Application No: CM/48/21/RES
Site Address: Land to the West of Church Lane South of Horsemere Green Lane Climping
Description of works: Approval of reserved matters following the grant of CM/1/17/OUT for the erection of 300 No dwellings & a building within use class E, together with public open space, LAPs, LEAP & ancillary works, including car parking & drainage arrangements, with access off Church Lane & Horsemere Green Lane. This application may affect the setting of listed buildings & is in CIL Zone 4 (HSP2) & is not CIL Liable.

Thank you for your internet representation made on 21st July 2022 which has been recorded as an objection with the comments as follows:

OWPC49255

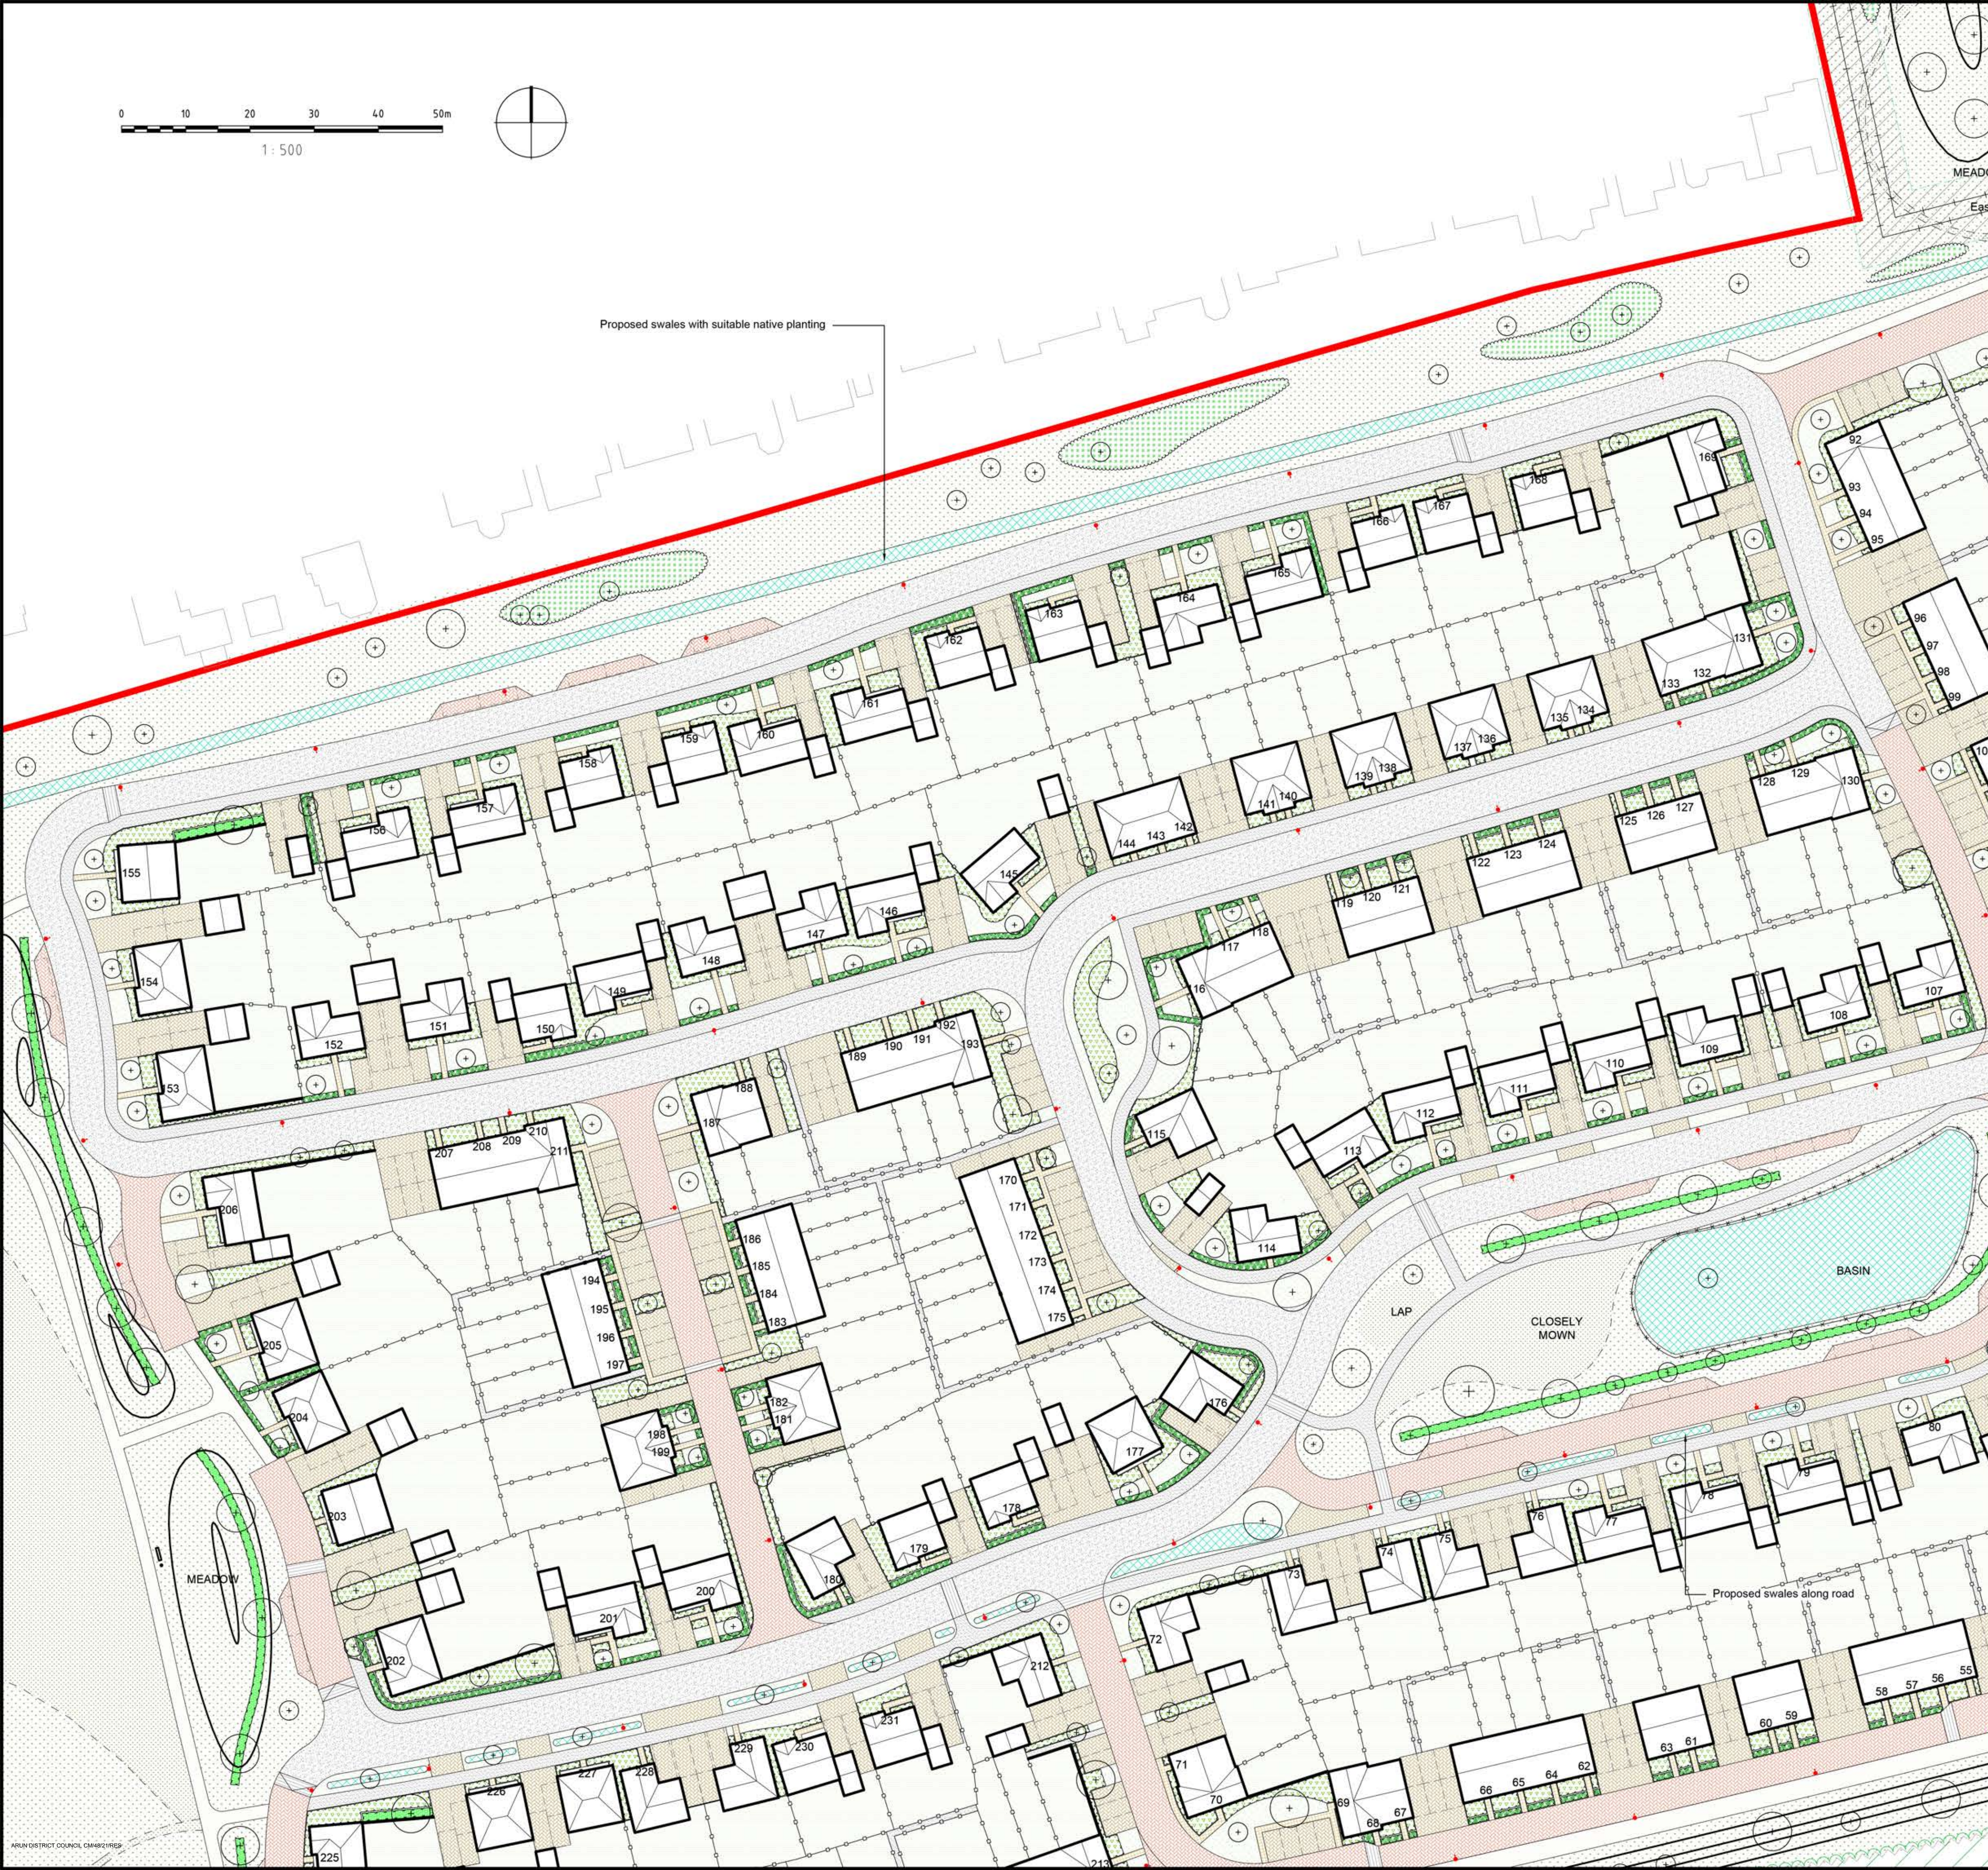
I am living directly at the field opposite dwelling 172.

I noticed on in Substitute Plan - Landscape Gen Arrangement Plan 3 of 7 LO3 REVE that at my South facing garden the plan is to plant a large tree (+10 meters in height). As this tree is likely to grow larger in time, this large tree will eventually block the sun out of parts of my garden.

I am objection against a large tree and suggest to change the plan to plant a large tree into a small of medium tree.
